ST ANTHONY OF PADUA SSD -8865 - RESPONSE TO REQUESTS FOR FURTHER INFORMATION

This letter supports the Response to Submissions report (RTS) provided to you on 18 November 2019 in respect of SSDA_8865 for the proposed St Anthony of Padua Catholic School (the Proposal) at 125-165 Tenth Avenue and 140-170 Eleventh Avenue, Austral (the site).

This letter has been prepared on behalf of SCS in response to NSW Department of Planning, Industry and Environment's (DPIE) request for additional information of 9 December 2019 and further request of 29 January 2020.

1 DIAGRAM - FENCING PLAN
1 : 1000

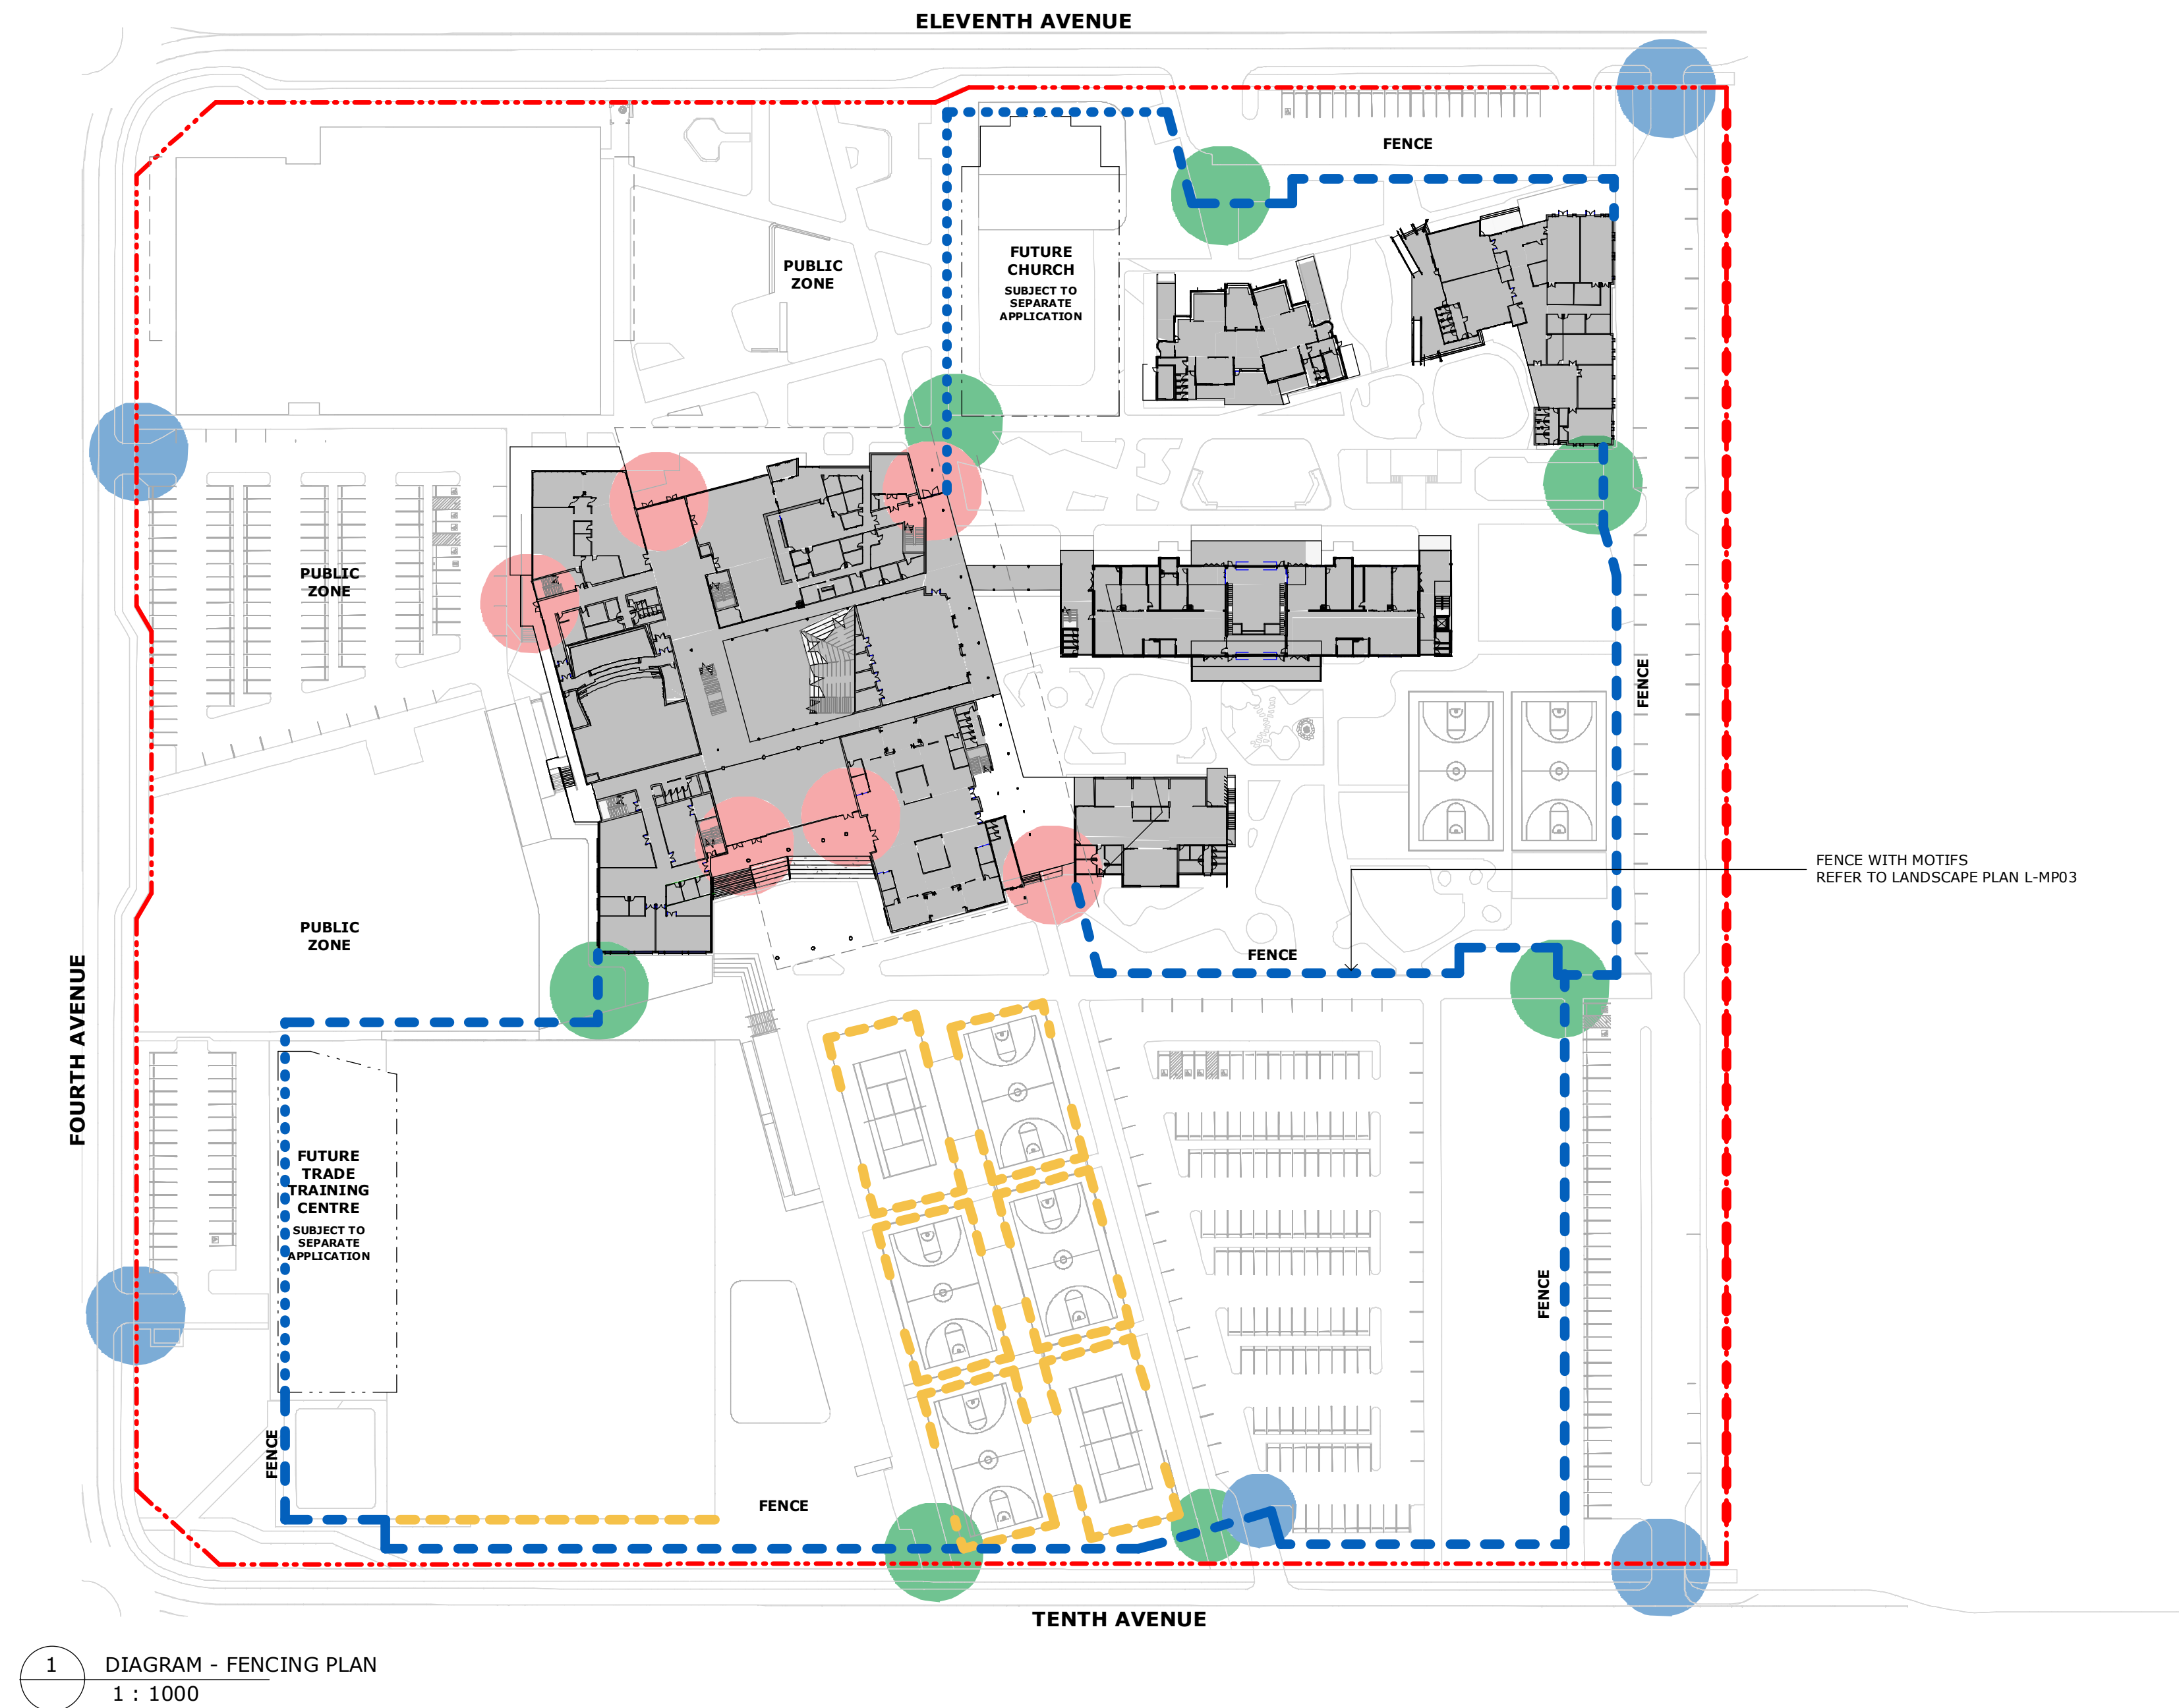
10.2 elevations and details of the proposed fence design and height should be submitted.	A fencing site plan has been prepared showing the proposed treatment of the site perimeter, including gates and entry points- refer DA60. This plan identifies the types of the fencing proposed and their heights. The fencing has been designed to be unobtrusive and allow for vegetation to be planted within the site and within the setback.	Attachment B- Architectural Plans – refer DA06_R2.

PROJECT NO.	DRAWING NO.	REVISION
4032	DA201	13

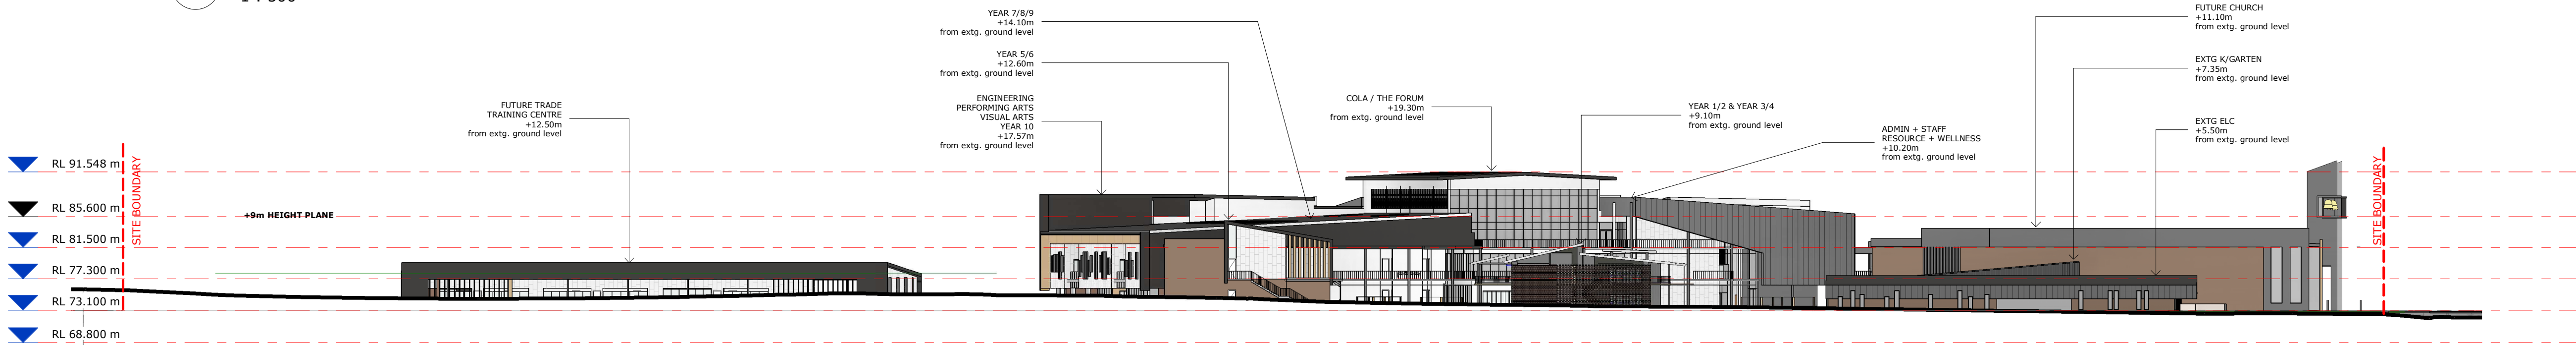
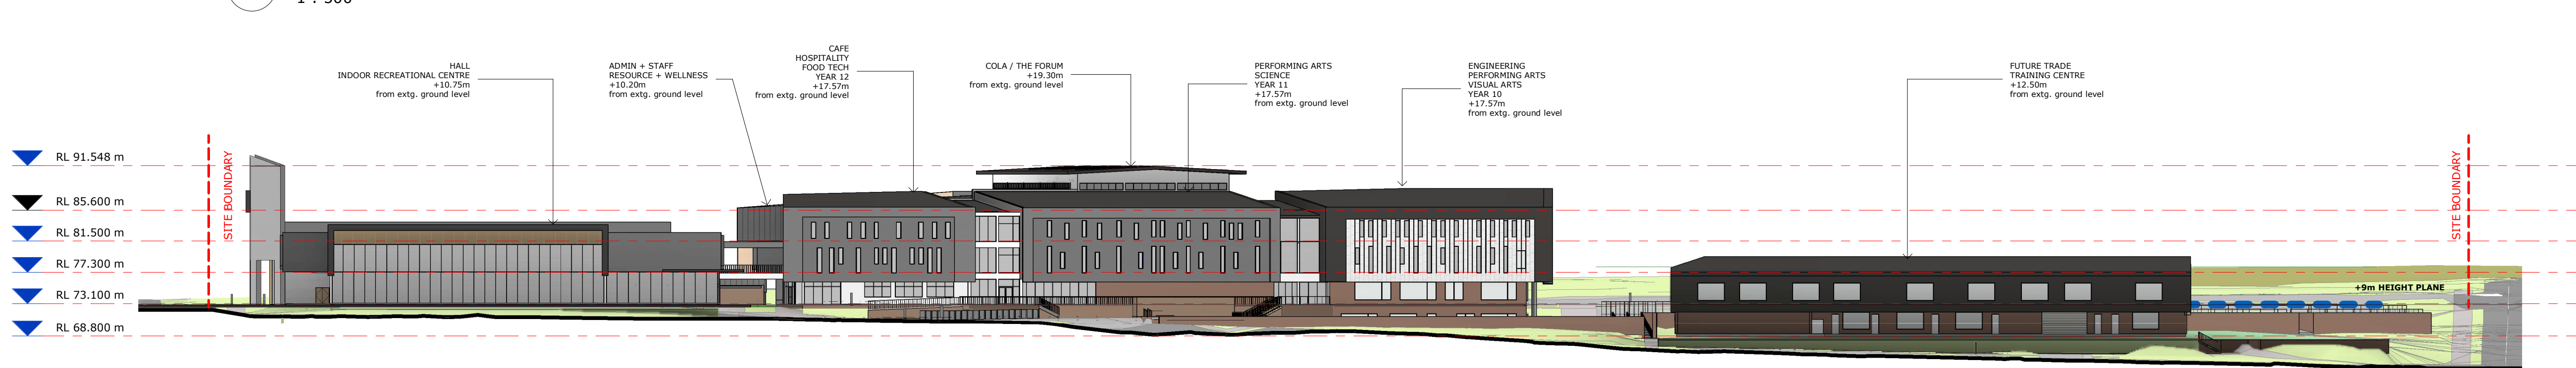
Matter	Response	Refer to
		around the school site and to cater to the anticipated traffic flows generated by the development.	
6	Building Height		
6.1	The submitted plans do not identify the proposed maximum building height (in metres above existing ground level) for any of the buildings on the site. A plan must be submitted which identifies the building heights for all buildings (including the Church and Trade Centre) above the existing ground level (not the upper most relative levels).	Refer to DA201_R13 which provides the heights of the buildings above the existing ground level.	Attachment A-Architectural plans – DA201_R13.
7	Contamination Assessment

PROJECT NO. 4032 DRAWING NO. DA351

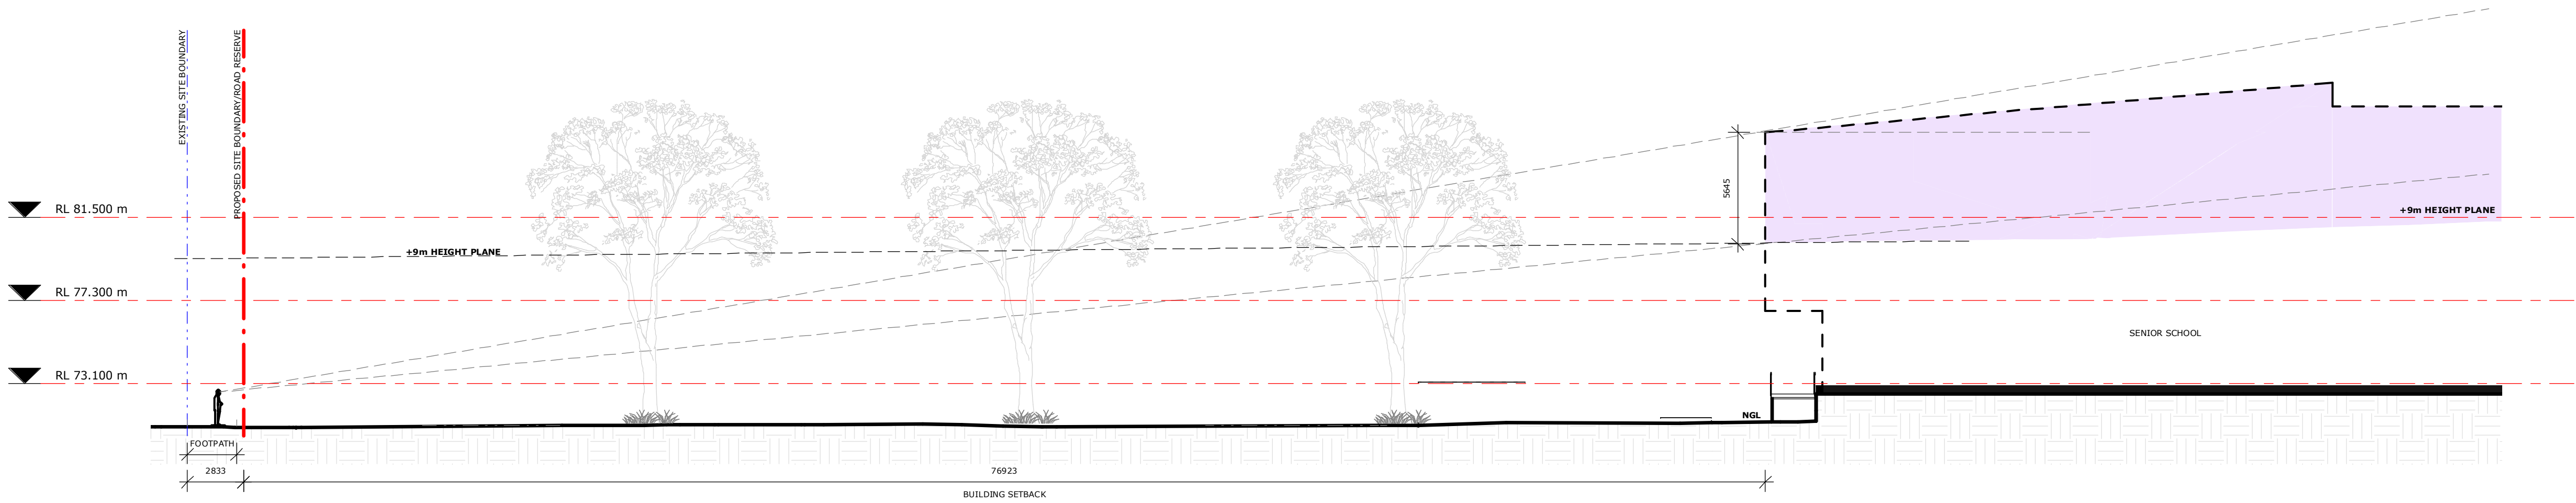
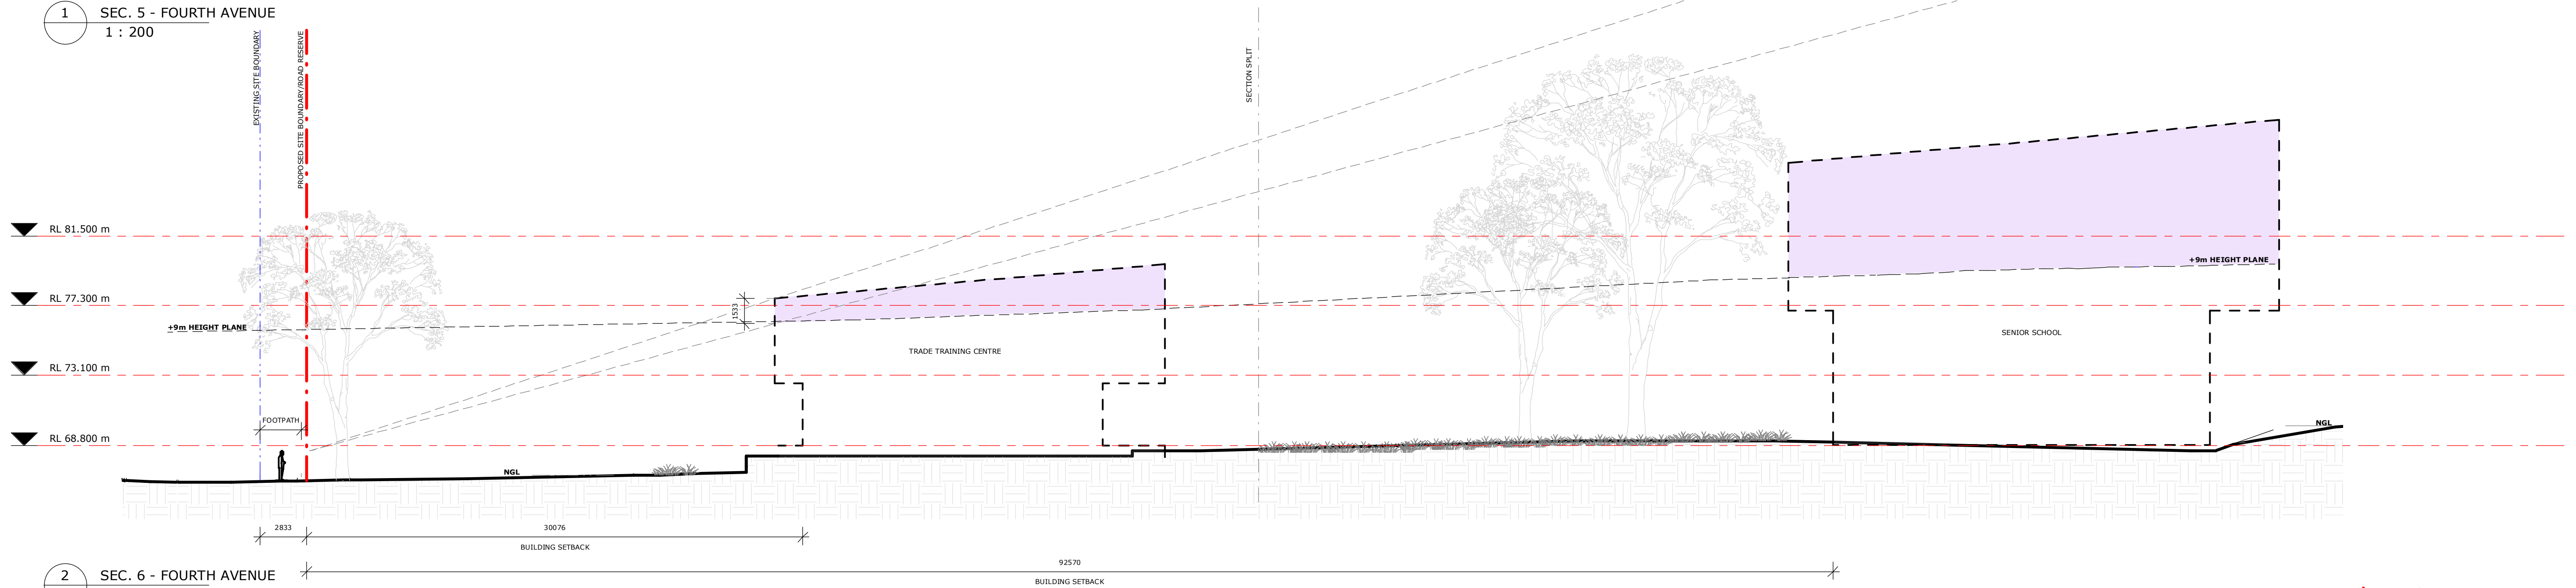
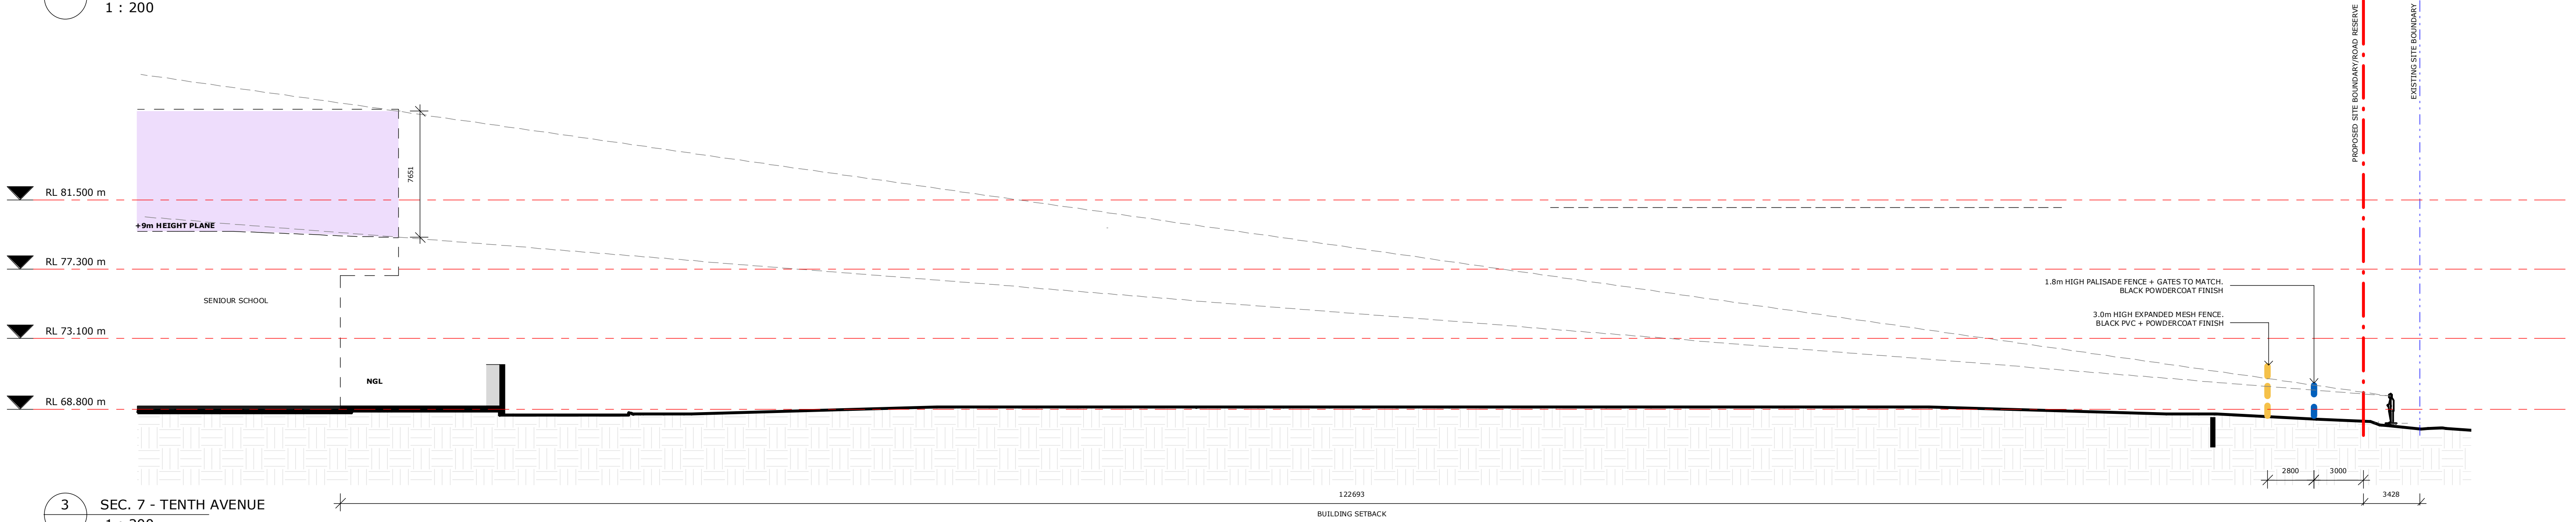
9.4 the EIS advises that the church and hall would maintain a 10m setback to Eleventh Avenue and 17.5m from Fourth Avenue. However, following changes to the site boundaries in order to accommodate the required road widening, the buildings setbacks would be amended. The submitted plans do not specify the revised setbacks of these buildings to the street frontages.	<p>Following the road widening of Eleventh Avenue the Indoor Recreation Centre will be setback approximately 4.75m from the site boundary and the Church building will be setback approximately 6m from the site boundary.</p> <p>Following the road widening of the western side of Fourth Avenue the Indoor Recreation Centre will be setback approximately 10m from the site boundary to the building façade.</p> <p>There are no existing or proposed residential land uses to the north of the site as this land is occupied by Craik Park an existing public open space.</p> <p>While the setbacks have been reduced, they maintain compliance with the non residential setbacks specified in Liverpool Growth Centre Precincts Development Control Plan (Precinct DCP). The setback to Fourth Avenue will be supported by the avenue planting specified in the landscape plan and the scale of the Indoor Recreation Centre will no be unduly imposing or dominant in the streetscape. This is illustrated in the perspective images prepared by MSM, refer especially to DA407.</p>	Attachment A- Architectural Plans – refer DA351 and DA 352 and perspectives images DA406, DA407, DA408
